**From:** [REDACTED]  
**To:** [Robin Proebsting](#)  
**Subject:** Comments re: 2825 W Mercer Way (File No SUB19-002)  
**Date:** Tuesday, May 7, 2019 8:05:46 AM

I have multiple concerns about the properties going up on and around 2825 W Mercer Way.

SITE PLAN
2825 W MERCER WAY
PRELIMINARY PLAT
 PARCEL #2174502425
 CITY OF MERCER ISLAND WASHINGTON

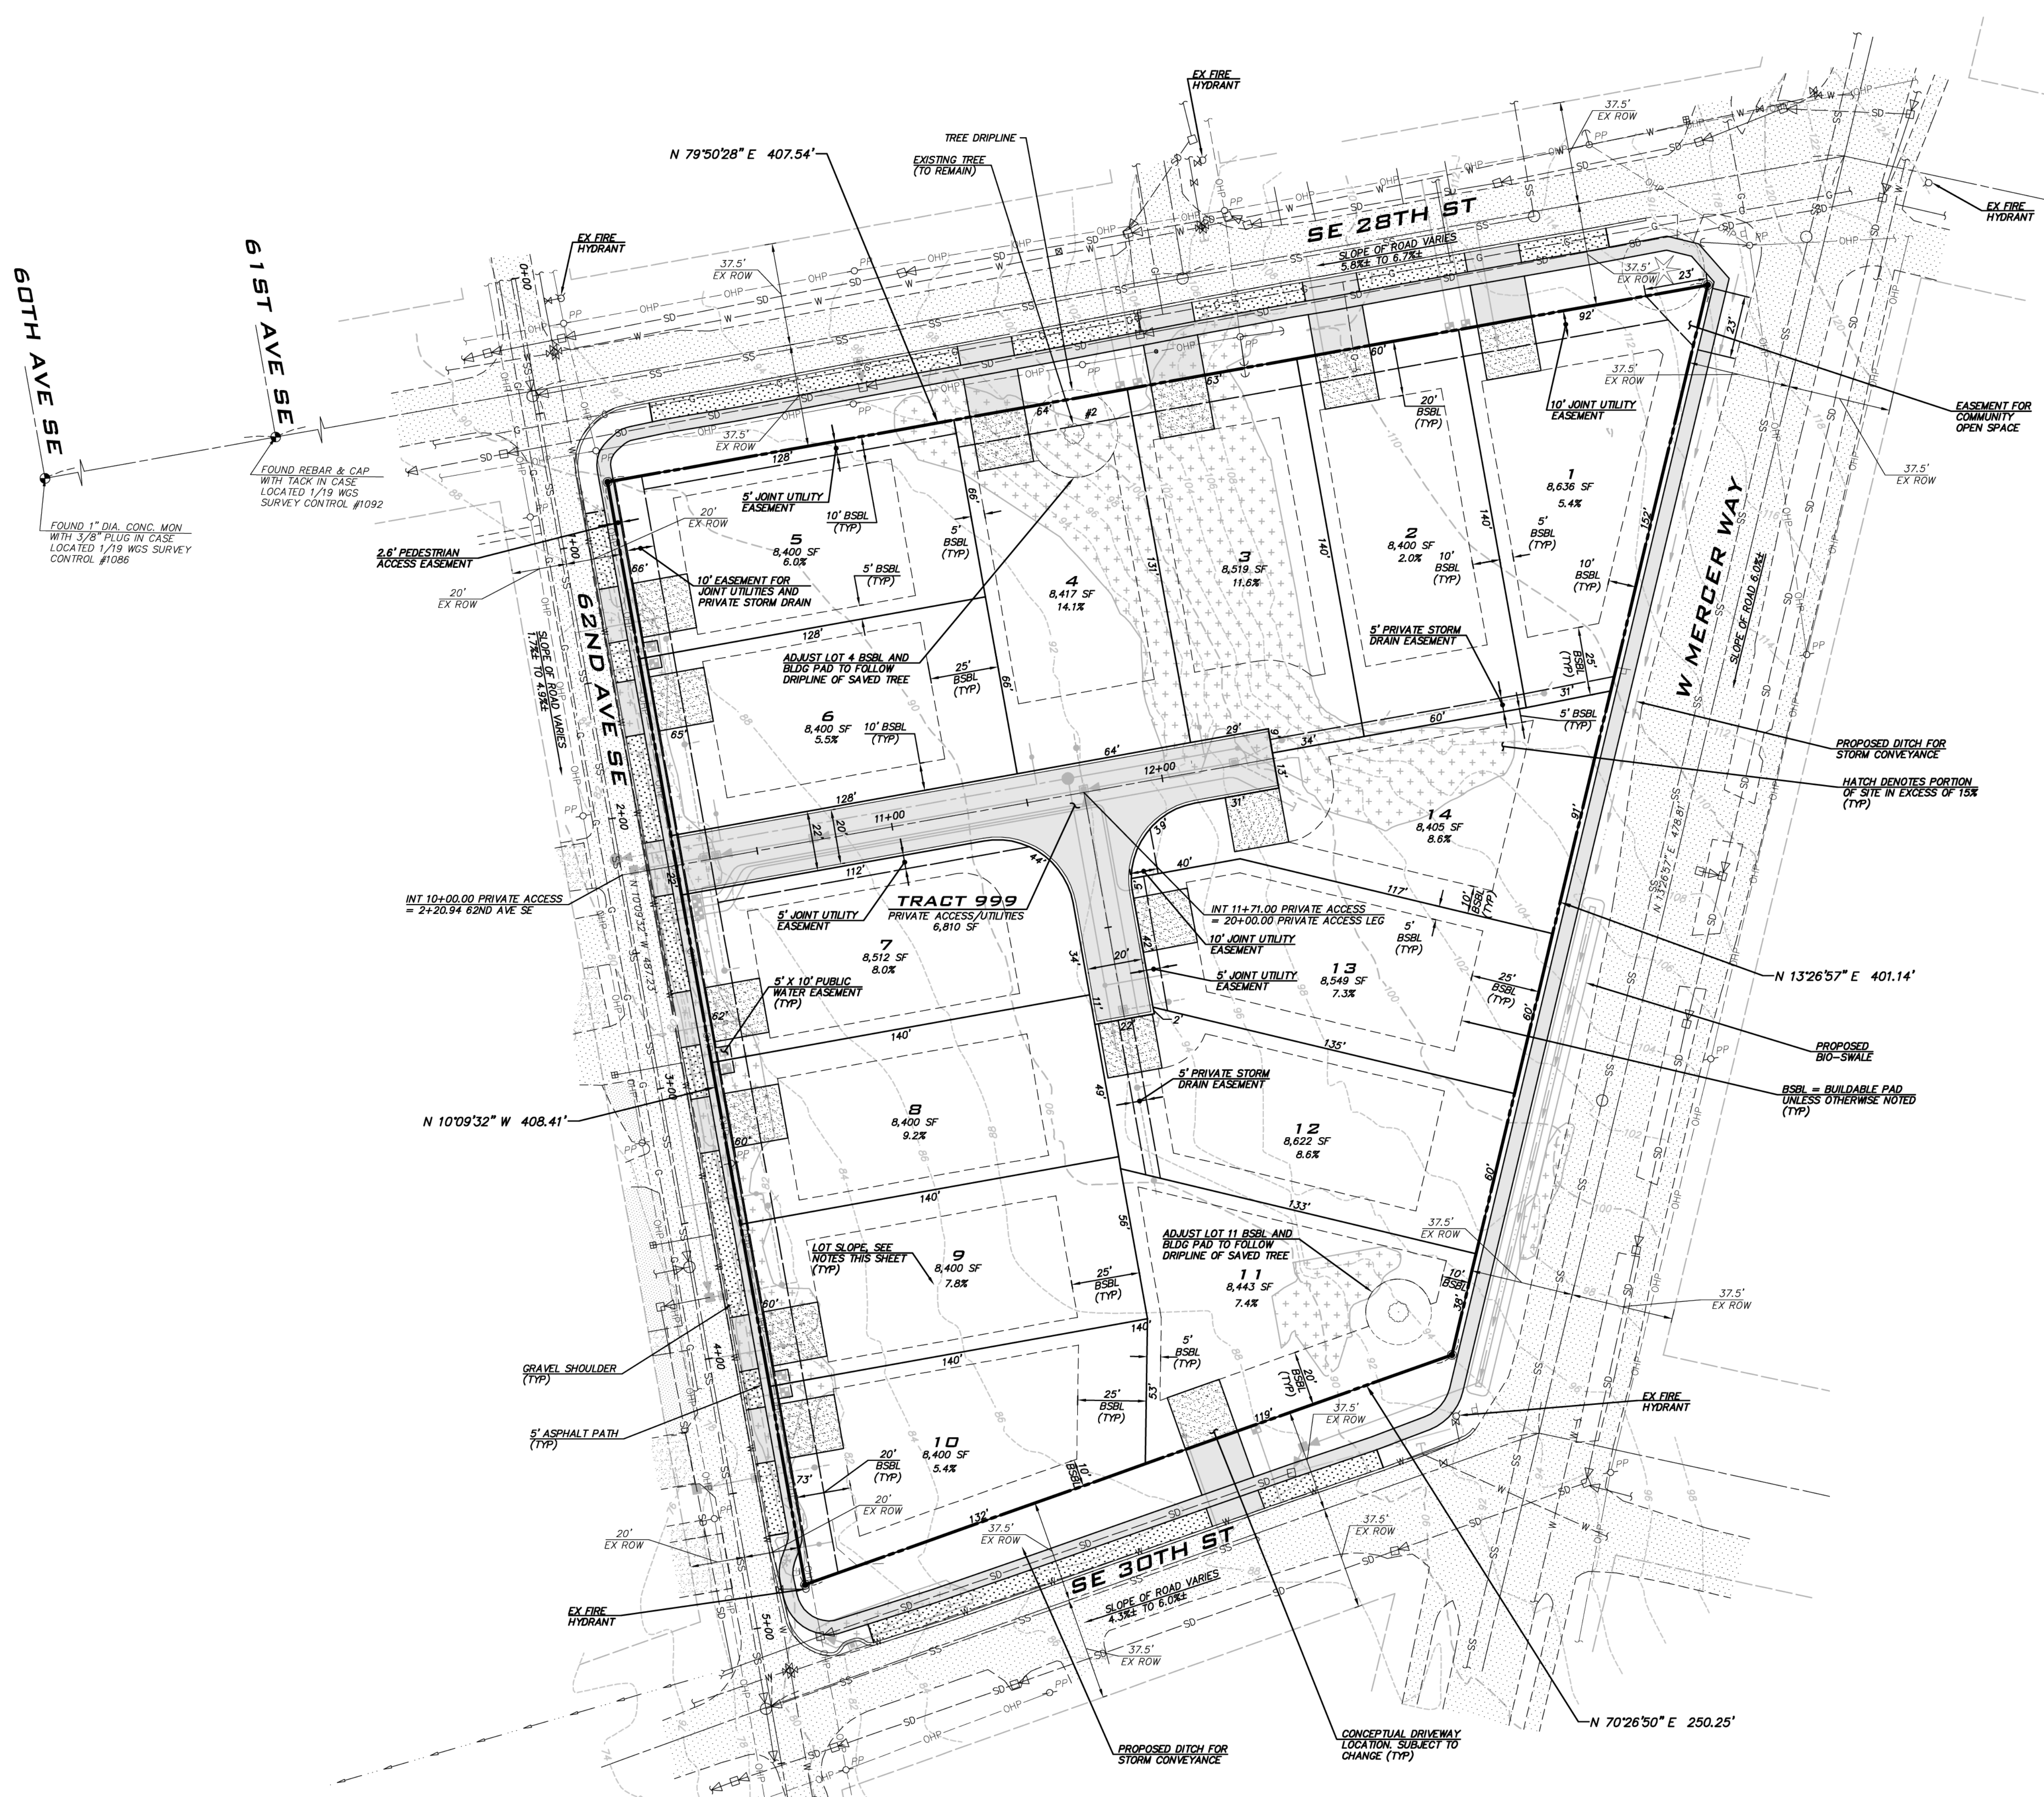
1) Impervious surfaces: The developer is asking for an exception to increase impervious surfaces to 52%, which is WELL above the code limit for this property/slope. I've wanted to develop/redevelop areas of my property that are grandfathered in via legacy rule. However, I was told that if I modernize I need to get everything up to code. Why would this developer get a pass? There is no reason to create so much impervious surface other than to have more houses and a road to serve so many houses. If the developer chose to have fewer houses he wouldn't need a private access road nor would he need such an exception.

4) "Community open space". The Public Notice of Application states the new development "will contain an area of community open space." I do not see this on any of the plans which leads me to infer that this application is either 1) misleading or 2) includes a community space so small it would be insignificant. I highly recommend that Mercer Island consider the current use of this space and allow for significant public space going forward.

PRELIMINARY TREE RETENTION AND REPLACEMENT PLAN
2825 W MERCER WAY
PRELIMINARY PLAT
 PARCEL #2174502425
 CITY OF MERCER ISLAND WASHINGTON

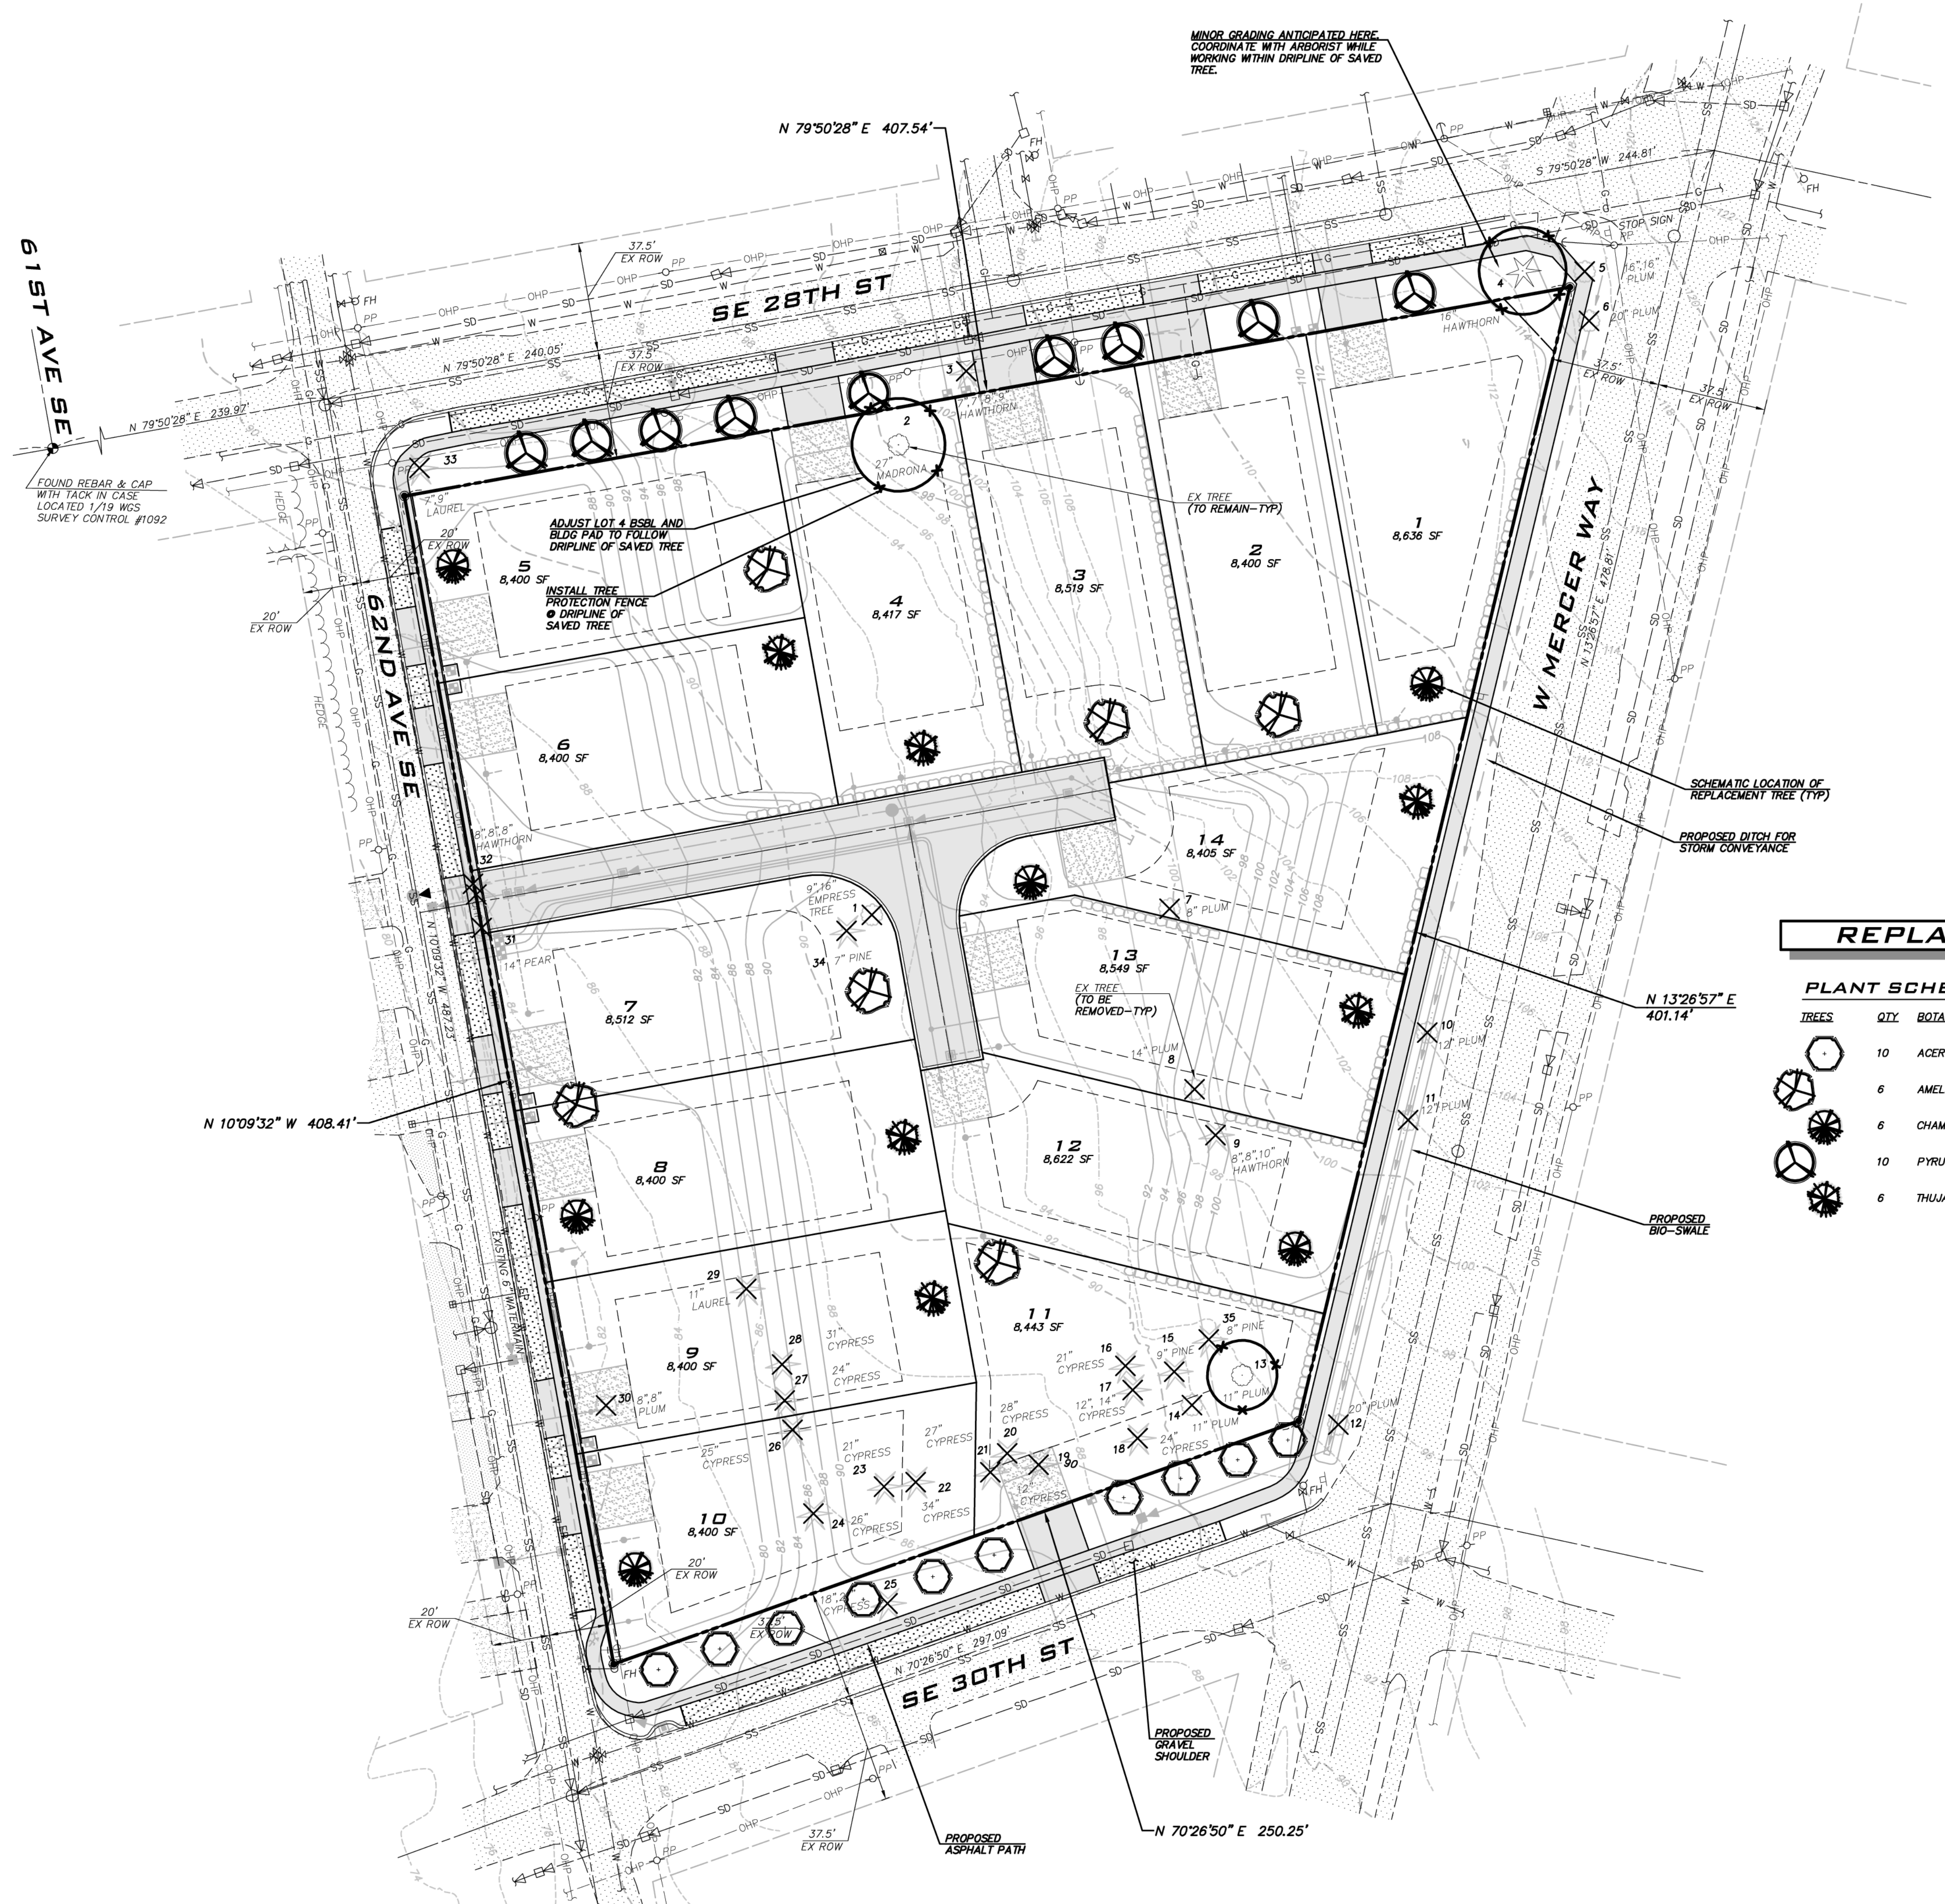
2) Tree felling: I take issue with the destruction of exceptional and significant trees. There is NO reason to take down exceptional trees in this case. The arborist states that removal of buildings/foundation would kill trees. Looking at the trees I would disagree. I would also recommend the investigation of alternative plans that don't require so much butchering of trees. If removing of foundation may kill an exceptional tree, then don't remove that section of foundation!
